Our reference: DOC15/470480-2
Contact: Robert Gibson, 4927 3154

RE: GREATER RAVENSWORTH AREA TAILINGS PIPELINE MODIFICATION ENVIRONMENTAL ASSESSMENT

ATTACHMENT 1: REVIEW OF THE ENVIRONMENTAL ASSESSMENT FOR THE GREATER RAVENSWORTH AREA TAILING PIPELINE MODIFICATION (DA 53-03-99 MOD 7, MP 09 0176 MOD 3 & DA 305-11-01 MOD 6) WITH RECOMMENDED CONDITIONS OF APPROVAL

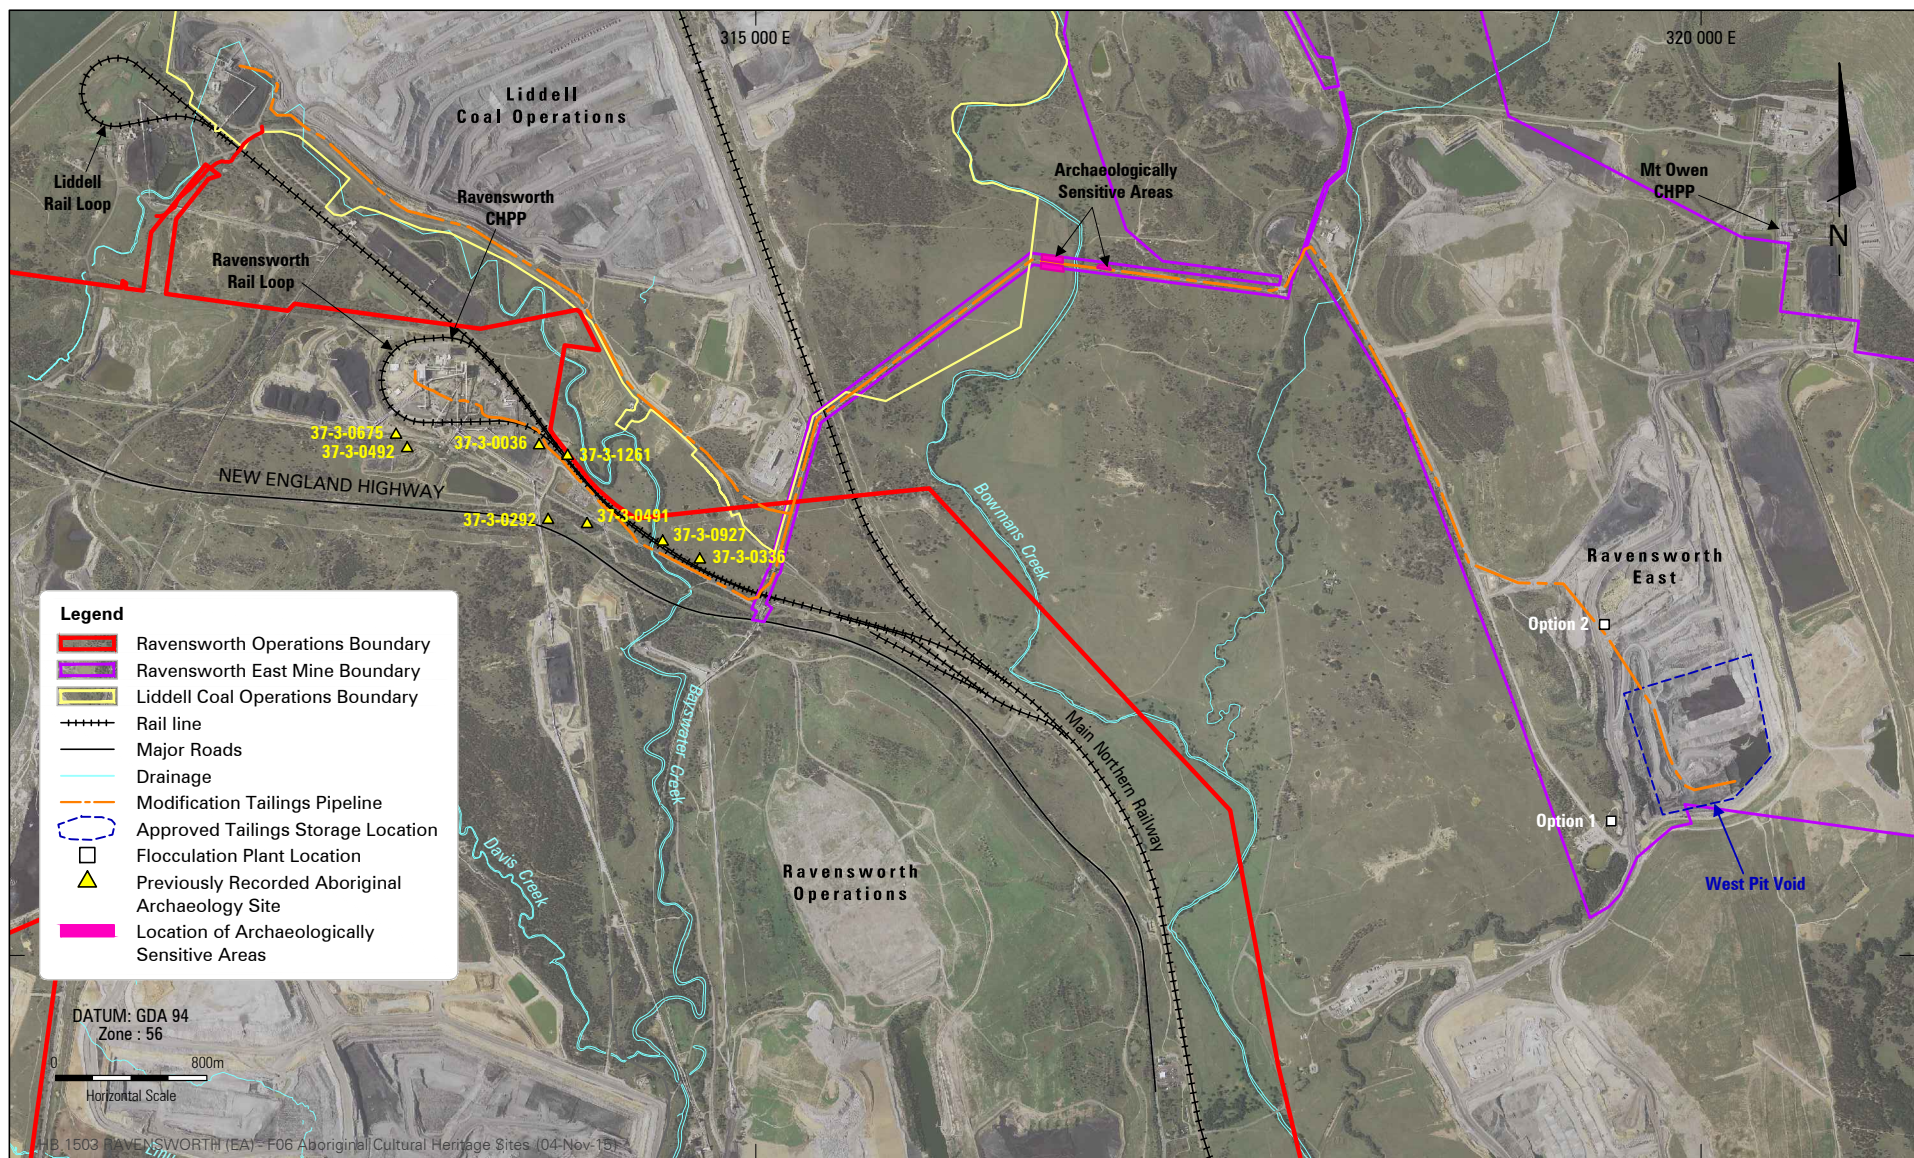
- b) No impacts from the Modification should occur within Sensitive Areas 1 and 2. To ensure that there are no inadvertent impacts to these areas, temporary fencing should be erected during construction at the following locations; along the northern and southern boundaries of the Modification for the length of Sensitive Area 1; and along the northern boundary of the Modification for the length of Sensitive Area 2.
